From: Jim Baldwin <jim.baldwin@campbelltown.nsw.gov.au>
Sent: Tuesday, 16 August 2016 7:50 AM
To: Thomas Piovesan
Cc: Karen Robinson; Luke Joseph
Subject: SSD 7500 5 and Culverston Road, Minto - State Significant Development

I refer to your correspondence regarding the State Significant Development application at Culverston Road, Minto.

Apologies' for the delayed reply, but I can advise that Council has reviewed the subject SSD application, and as a consequence of that review, raises the following concerns:

Drawing Title: **SITE MASTERPLAN (OVERALL)**
Drawing Number: **116101_A_SSD_A0006**

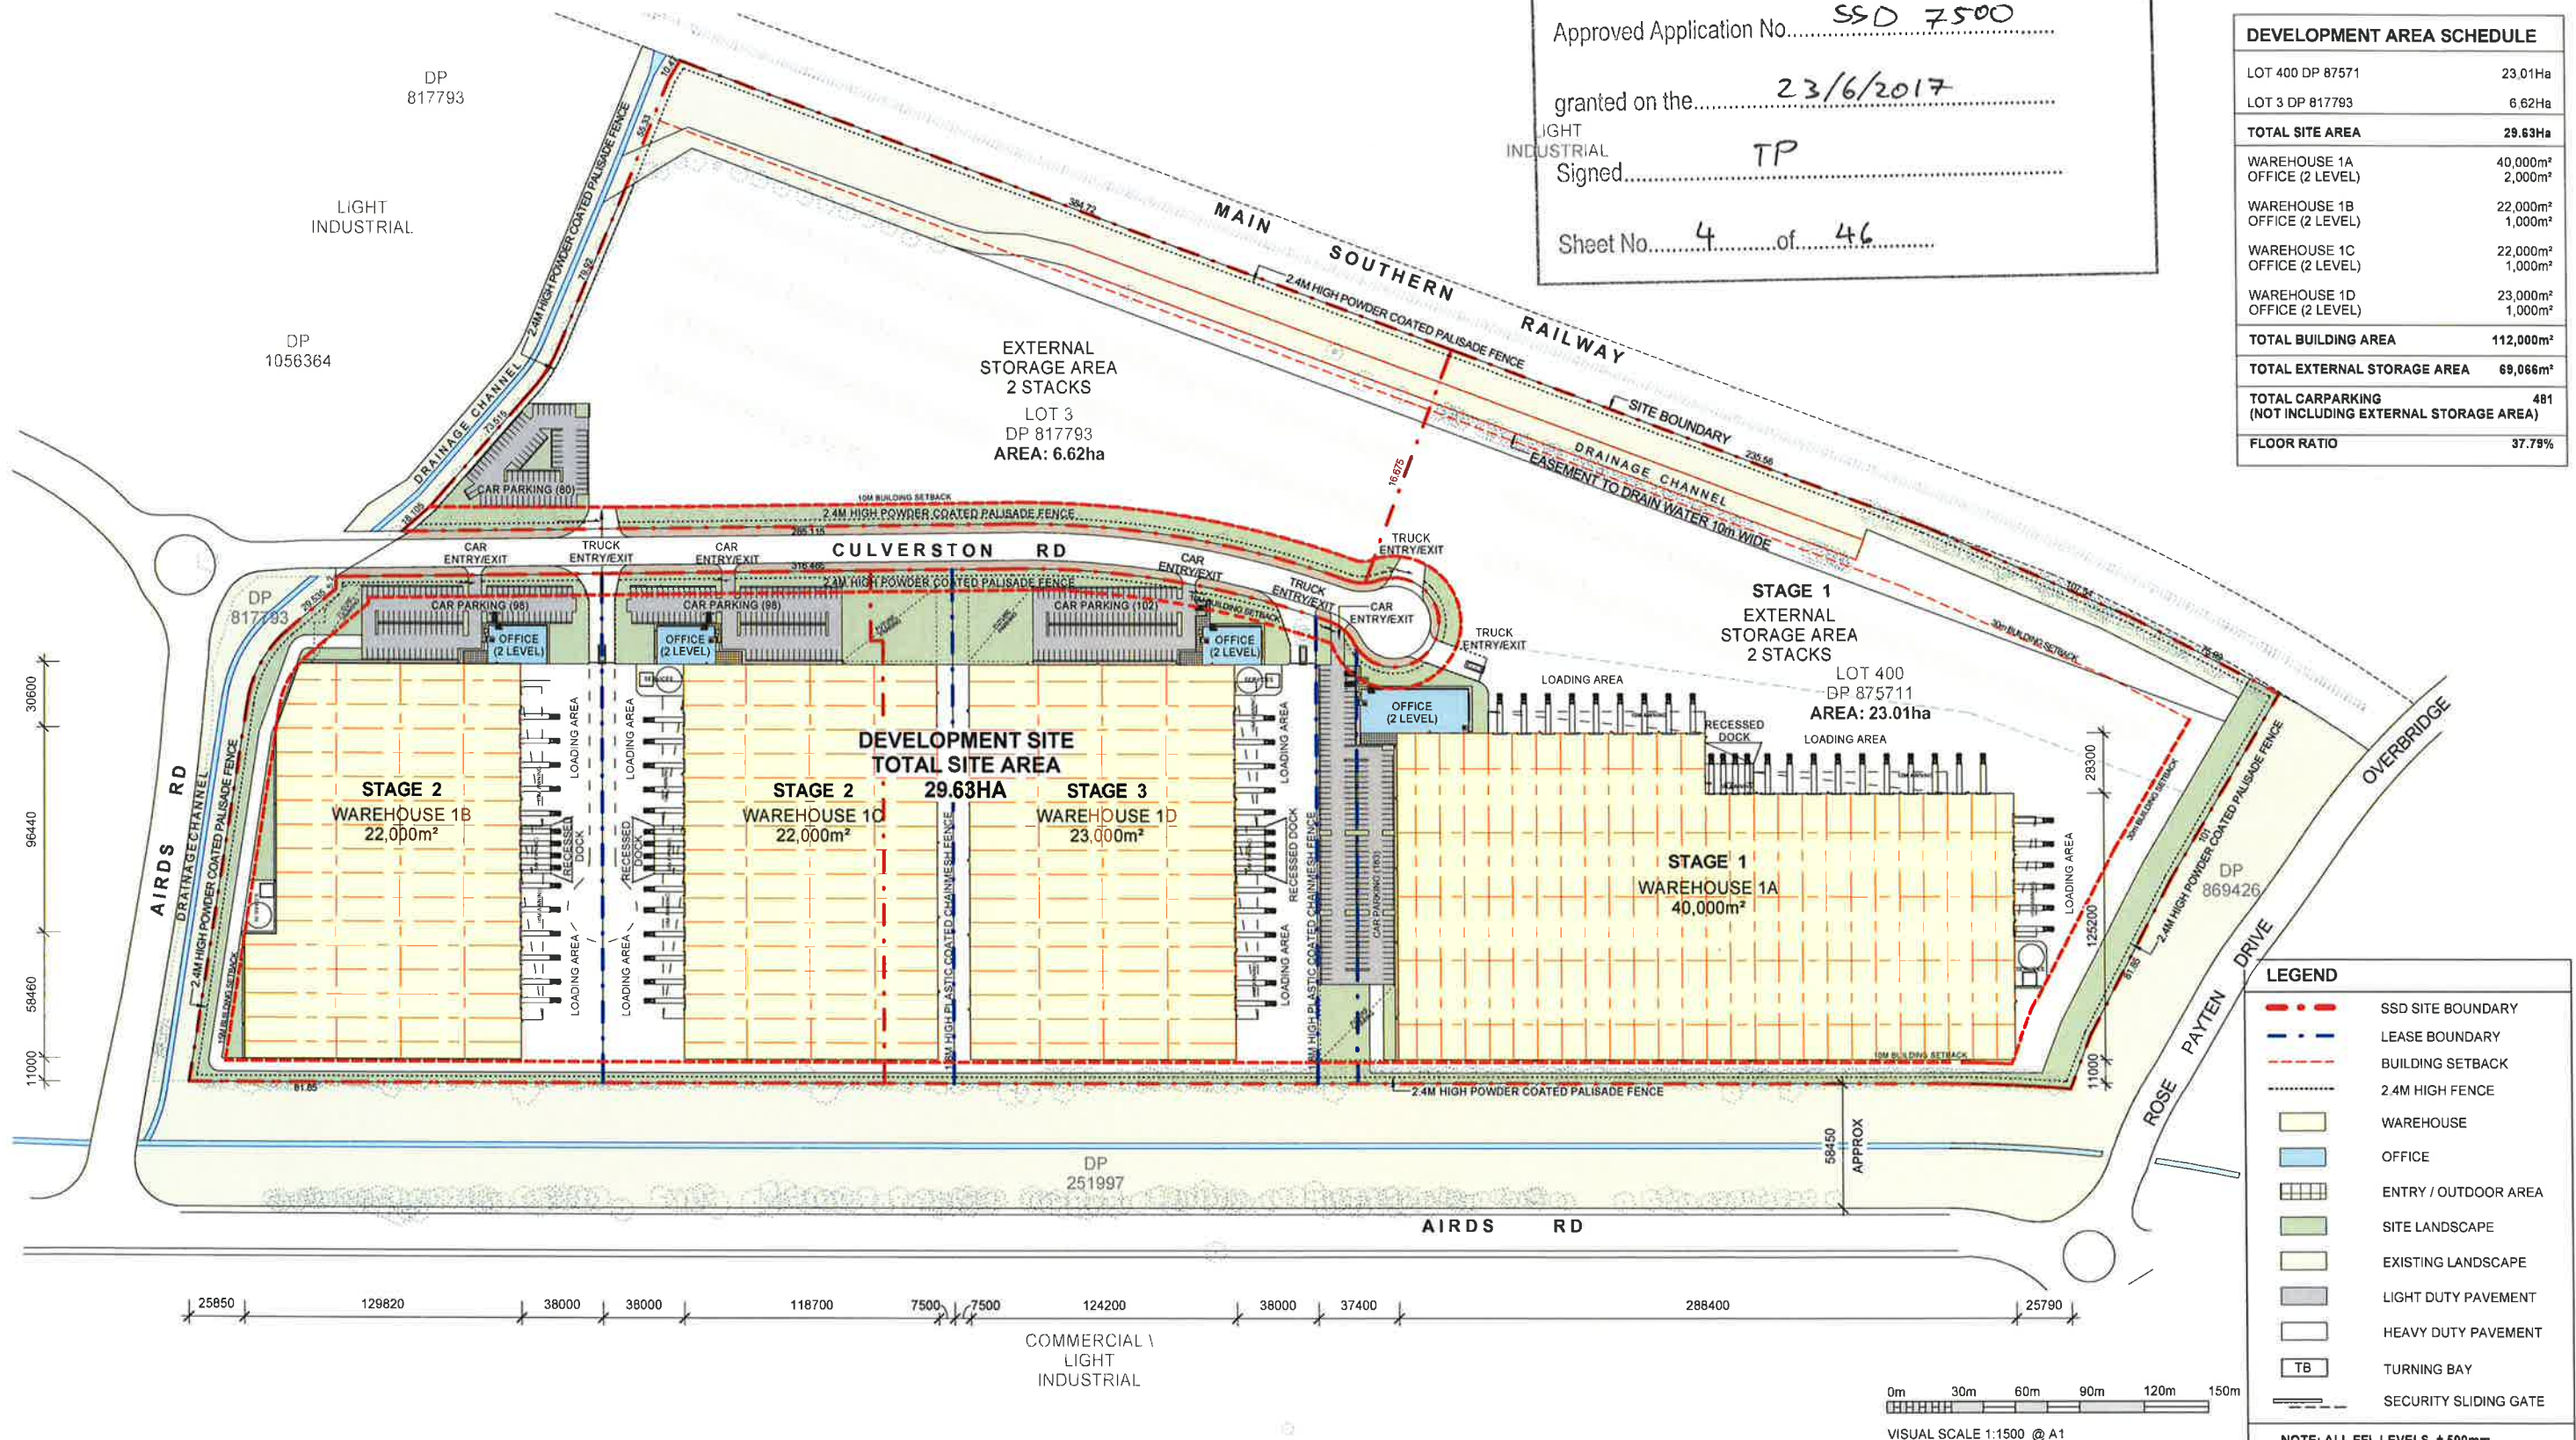
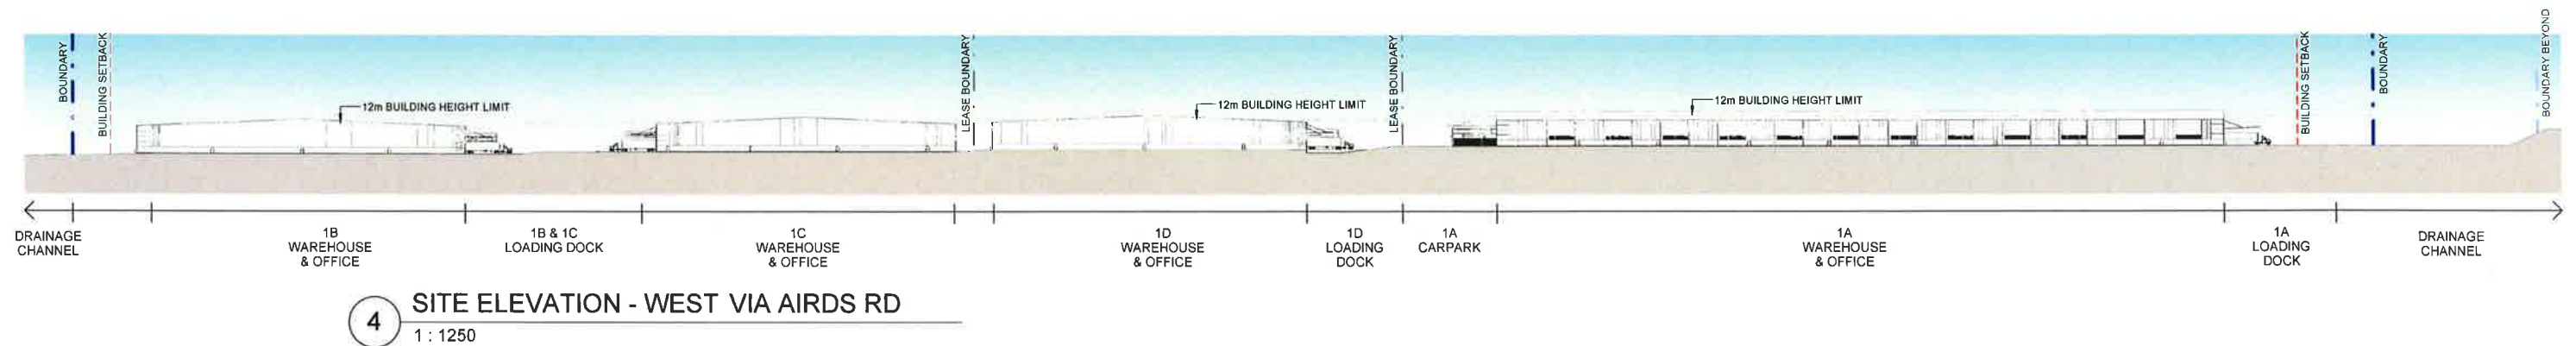
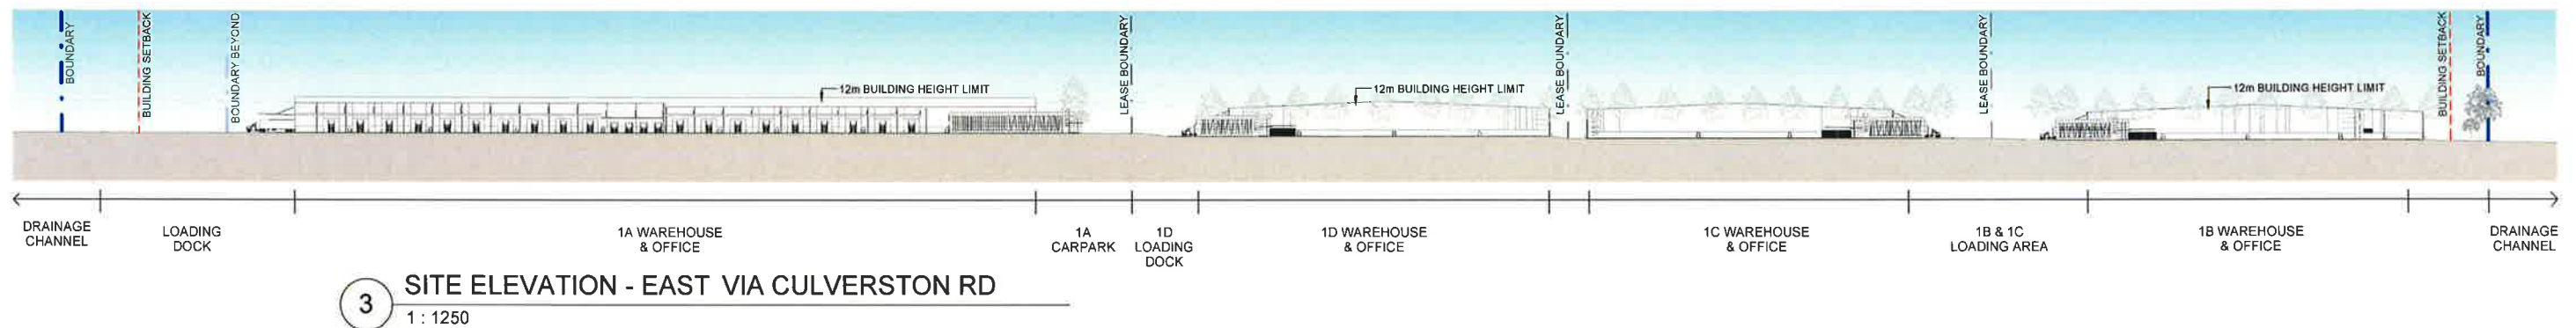
1. The proposed outdoor storage areas will not be adequately screened from public places (Culverston Road, Rose Payten Drive and the Main South Rail Line). This matter was raised with the applicant at the pre lodgment stage and it is evident that this matter, and the importance of this matter to the Council, has not been given the anticipated attention. Council strongly objects to any outdoor storage area that is not adequately screened. The relevant clauses of Part 7 of the Campbelltown Sustainable City DCP 2015 are listed below:

All screening structures shall be located behind the required landscaped areas. Specifically, landscaping fronting the Main South Rail Line and Rose Payten Drive shall be of significant height so as to obscure views of the site.

Council also requests clarification as to whether the outdoor storage area would be used to store containers, and if so, the height of such container storage. Council would not support more than two containers in height from natural ground level. Council also requests clarification of whether any loading and unloading of goods, or any other industrial activities would take place within these storage areas. All industrial activities should take place within the proposed buildings and not in outdoor / exposed areas.

2. The front fencing to the development fails to comply with Part 7 of the Campbelltown Sustainable City DCP 2015:

Council requests that the front fencing to the development be setback 3 metres and the area between the fencing and the property boundary landscaped, in accordance with Council's policy.
